<b>Application Ref:</b>	3/2025/0929			 Ribble Valley Borough Council <small>www.ribbonvalley.gov.uk</small>
<b>Date Inspected:</b>	08/01/2026	<b>Site Notice:</b>	n/a	
<b>Officer:</b>	MC			
<b>DELEGATED ITEM FILE REPORT:</b>				<b>REFUSAL</b>

<b>Development Description:</b>	Change of use of the existing dwellinghouse (C3) to a small children's residential home (C2).
<b>Site Address/Location:</b>	17 Redwood Drive Longridge PR3 3HA

scale	1:50	002
@ sheet size	A1	drawing number revision

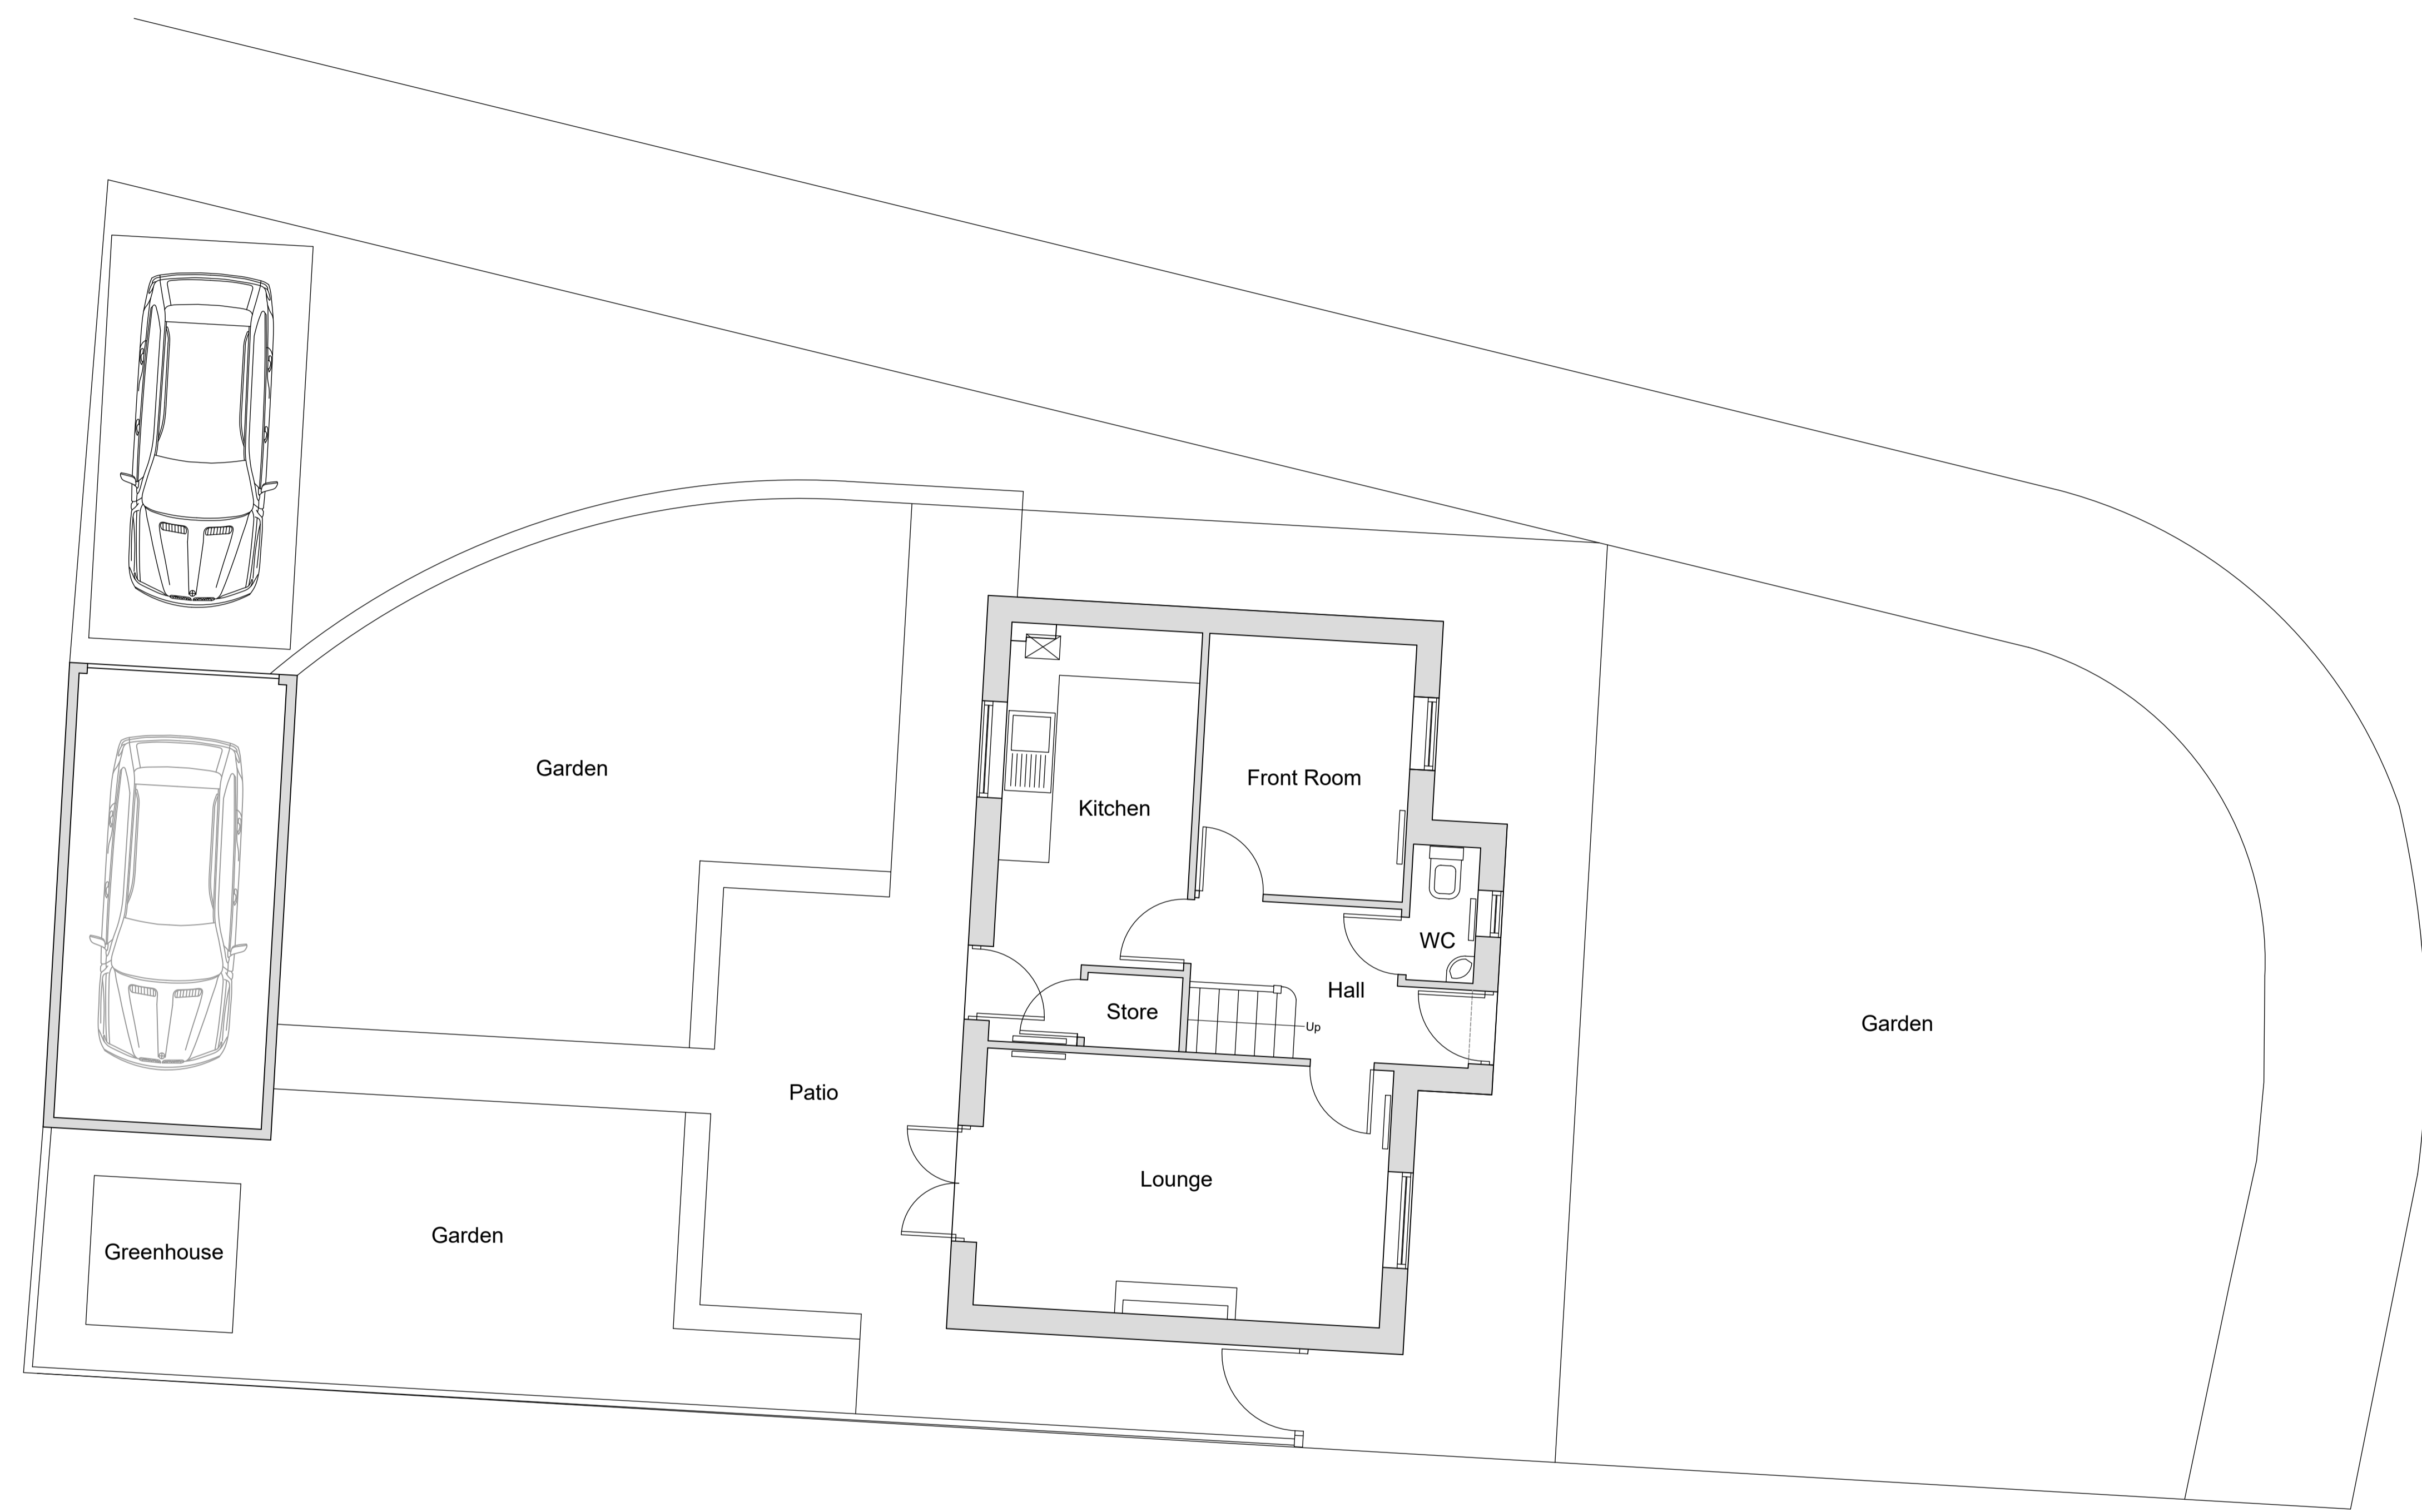
Despite the planning statement advising that there would be no changes to the dwelling, including the creation of new driveways, drawing ref: 003 shows the paving over of part of the front garden to create two additional driveways. It should also be noted that the tree which is located to the front of the driveway is not shown on the existing or proposed site plan.

scale	1:50	003
@ sheet size	A1	drawing number revision

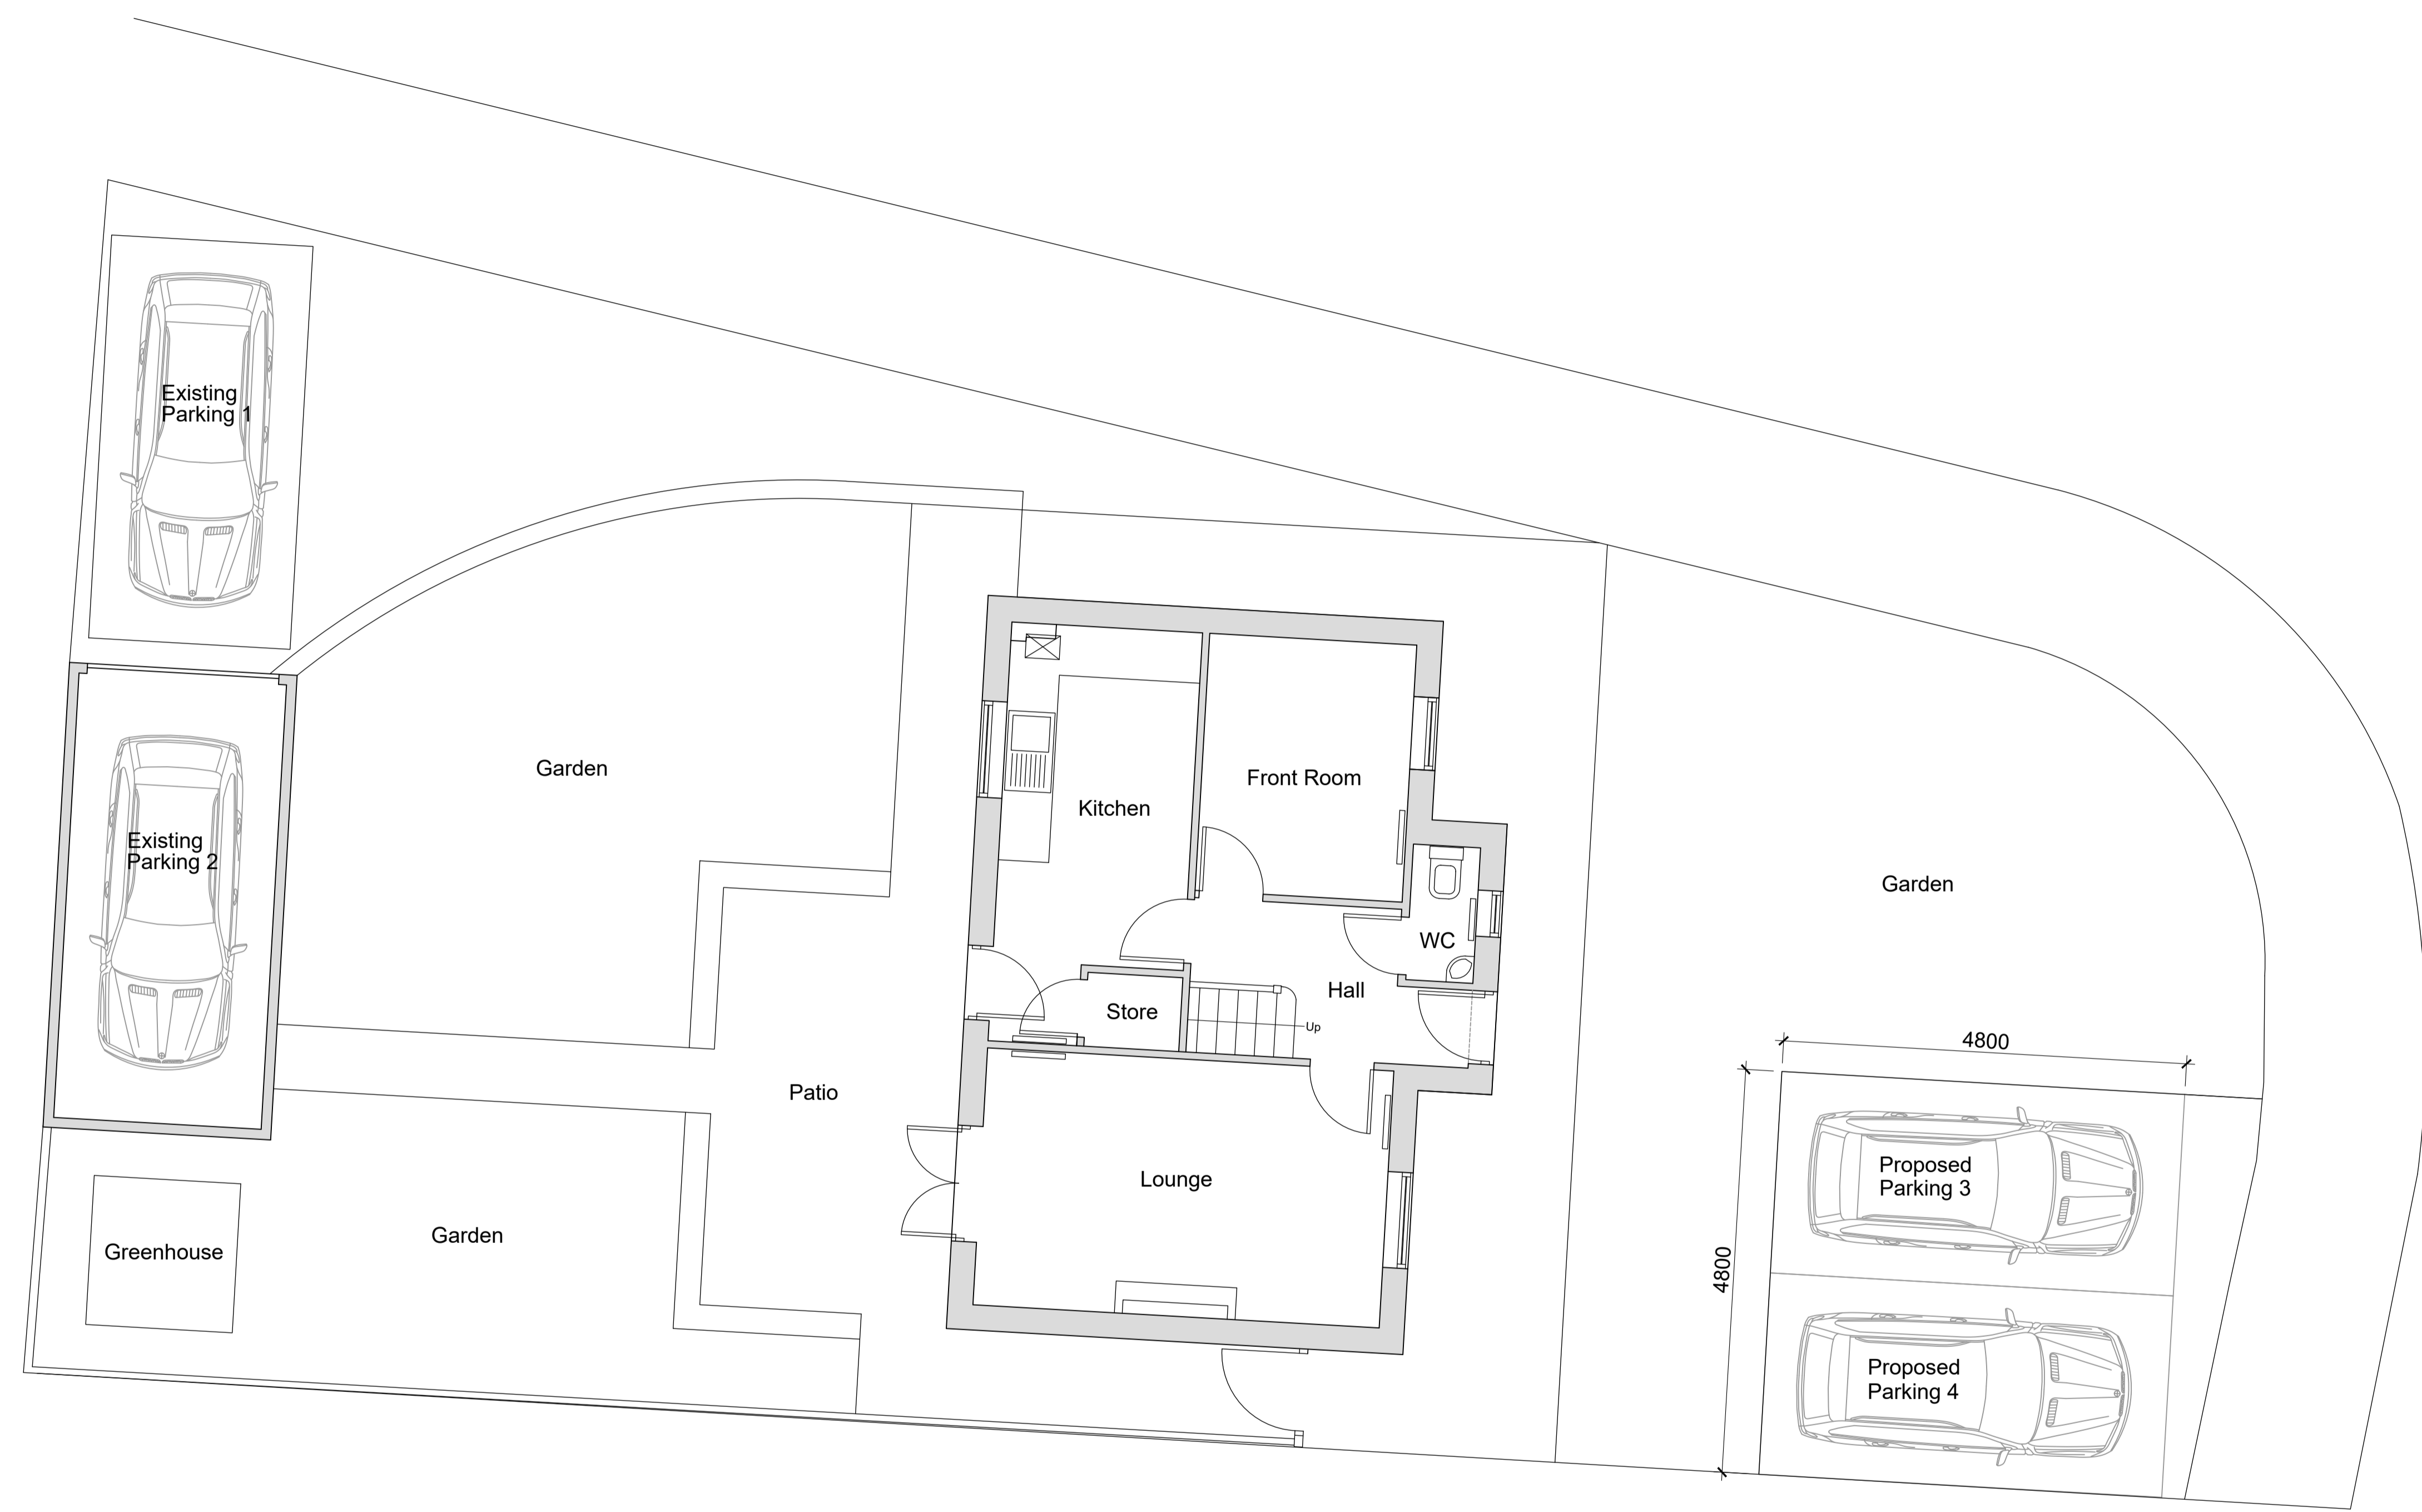
In addition, there is conflict between the submitted plans which indicate that there would be 2 no. additional parking spaces required and paragraph 4.5 of the planning statement which indicates that there would be no new driveways created as part of the proposed development. Whilst the site has a garage and parking space to the rear of the dwelling, the creation of two new parking spaces are proposed at the front of the site in accordance with drawing ref: 003. Any disturbance resulting from the proposed change of use would be exacerbated as the additional driveway would be located at the front of the site, within close proximity to other residential properties. There is limited provision for on-street parking adjacent to the dwelling as Redwood Drive is not a wide trunk road and therefore the presence of up to 4 no. vehicles in the road would be a noticeable difference, if staff were to choose to park on the road. The Council could not control that the staff members park on the driveway and given the lack of parking, would likely result in the changeover staff leaving cars parked on the street, which would result in harm to the amenities of neighbouring properties.

It is considered that the paving over of the front garden with a proposed driveway to facilitate a change of use would contribute to the change in nature of the site. As such, it is considered that the loss of front garden to facilitate a change of use would visually detract from the character and distinctiveness of the surrounding residential area, contrary to Policy DMG1 of the Ribble Valley Core Strategy and Policy LNPD3 of the adopted Longridge Neighbourhood Development Plan.

| <b>02:</b> | The loss of front garden to facilitate a change of use would visually detract from the character and distinctiveness of the surrounding residential area, contrary to Policy DMG1 of the Ribble Valley Core Strategy and Policy LNDP3 of the adopted Longridge Neighbourhood Development Plan.  |
